From: Norman [REDACTED]
Sent: 12 February 2016 14:43
To: M4 Junction 3-12 Smart Motorway
Subject: RE: M4 Junctions 3 to 12 Smart Motorway

I wish to make the following submission to deadline VII. This is a written summary of part of the oral submission I made at the Hearing on Environmental issues on 10 February 2016. The remainder of the points I raised at the Hearing I have already submitted in writing to deadline VI and are published on the website so I will not repeat them.

As a result of the Enhanced Noise Mitigation Study it is now proposed to erect a 2.5m high absorptive acoustic barrier of approximately 2km in length where the M4 passes Lower Earley. I welcome this and it will help the many residents of Earley who endure noise from the M4.

Project	SMART MOTORWAYS PROGRAMME
	M4 JUNCTIONS 3-12
Drawing title	ENVIRONMENTAL MASTERPLAN
	REGULATION 4(2)(e)
	SHEET 14 OF 61
	LOWER EARLEY

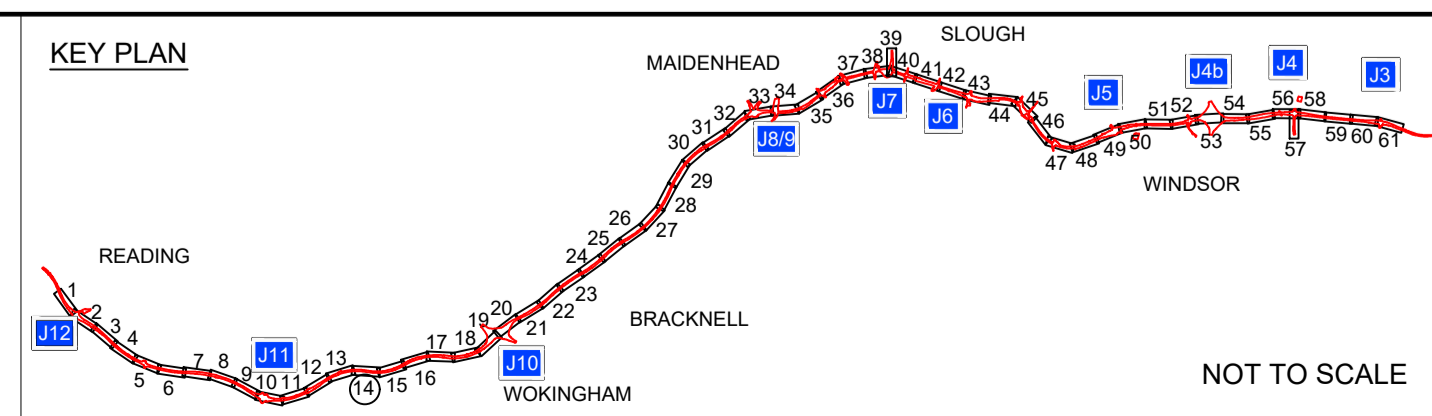
However, it appears that those areas which currently have protection from 2m or 2.5m high barriers are to have those upgraded to 3.5m high. Why not 3.5m high barriers for Lower Earley?

As the M4 goes past Lower Earley some properties are very close to the Motorway while others are further away. Please will you further consider the level of protection for those properties closest to the M4 in Lower Earley and specifically those located in Worrall Way, Tickhill Close, Notton Way, Finbeck Way and Maltby Way. These properties sit above the Motorway and as I demonstrated during the accompanied site visit to Notton Way on 9 February many properties currently have direct line of sight to the wheels of vehicles going by on the Motorway.

I submit that these properties at least should be provided with the same level of protection as those in Winnersh which are to be provided with 3.5m high barriers. This would require approximately 400m of the 2km long Lower Earley barrier to be 3.5m high rather than 2.5m.
